DECISION DELEGATED TO DEVELOPMENT MANAGER

Application No: H13-0593-20 **Applicant:** Jack Buck (Farms) Ltd.
Proposal: Proposed roof mounted solar panels
Location: Jack Bucks Farm Green Lane Moulton Seas End
Terminal Date: 14th September 2020

CASE OFFICER ASSESSMENT

Project JACKBUCK FARM - GRADING SHED		
Drawing Title ELEVATIONS		
Drawn By G.LIU	Approved By X.XXXXX	Scale (A1) 1:200
Drawing Status PROVISIONAL		
Drawing Number 69-00093 - P04-RE01		Date 20/07/2020

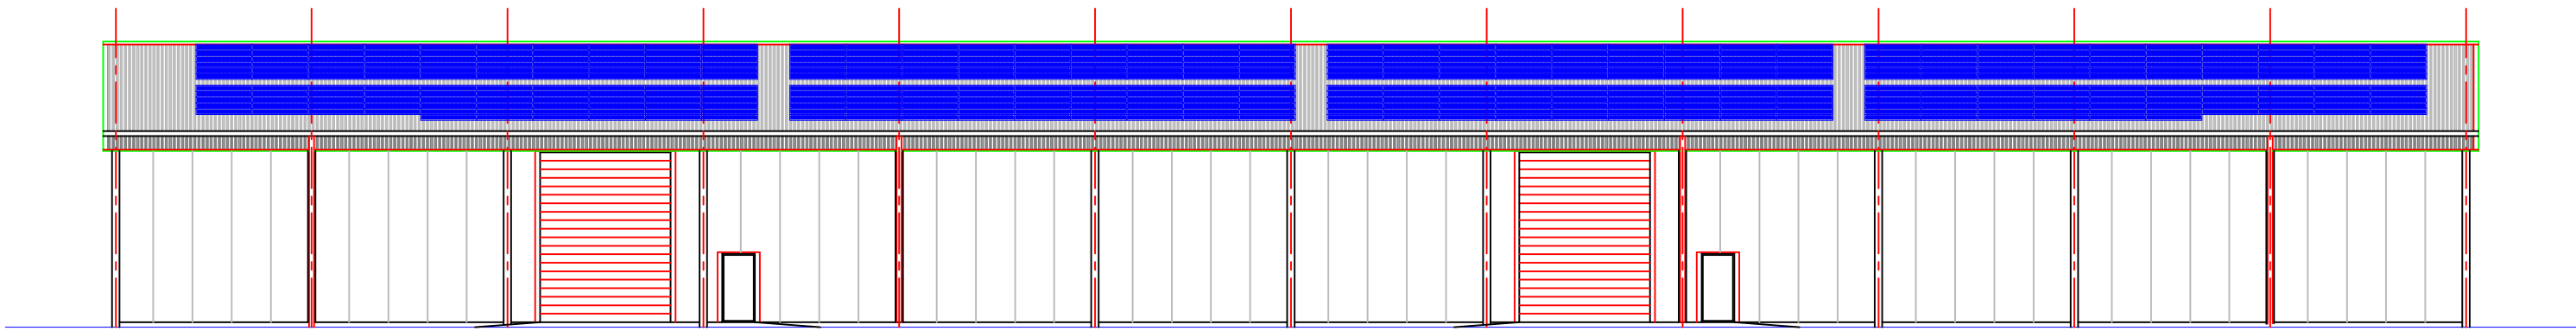
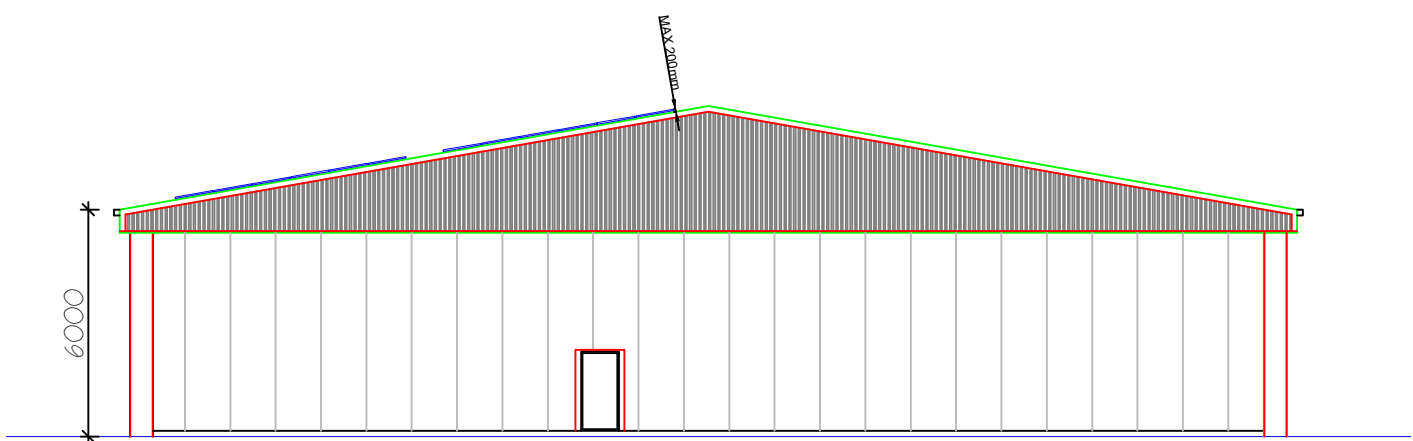
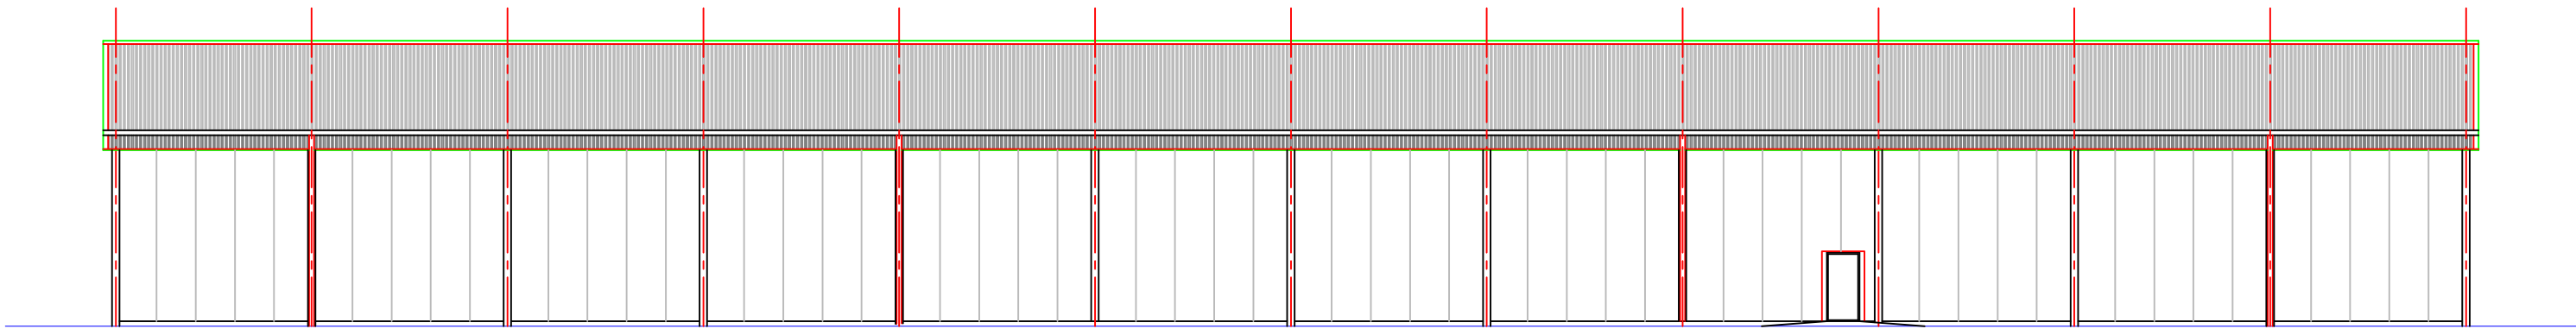
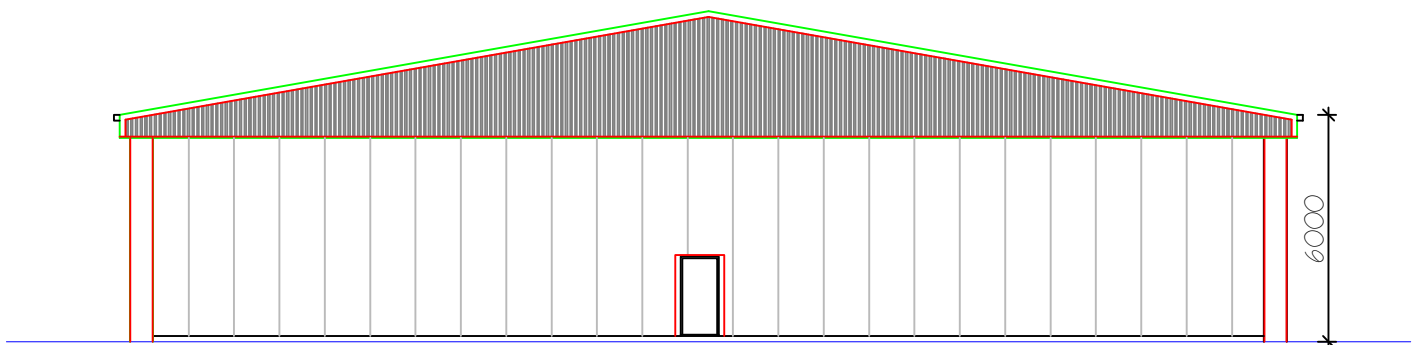
The proposed solar panels would be installed on both roof slopes of a dual pitched building. Their maximum protrusion from the roof slope will be 0.2 metres (expressed as 200mm on the Dwg. No. 69-00093-P04-RE01). All panels will be at least set back 1.46 metres from the external edge of the roof.
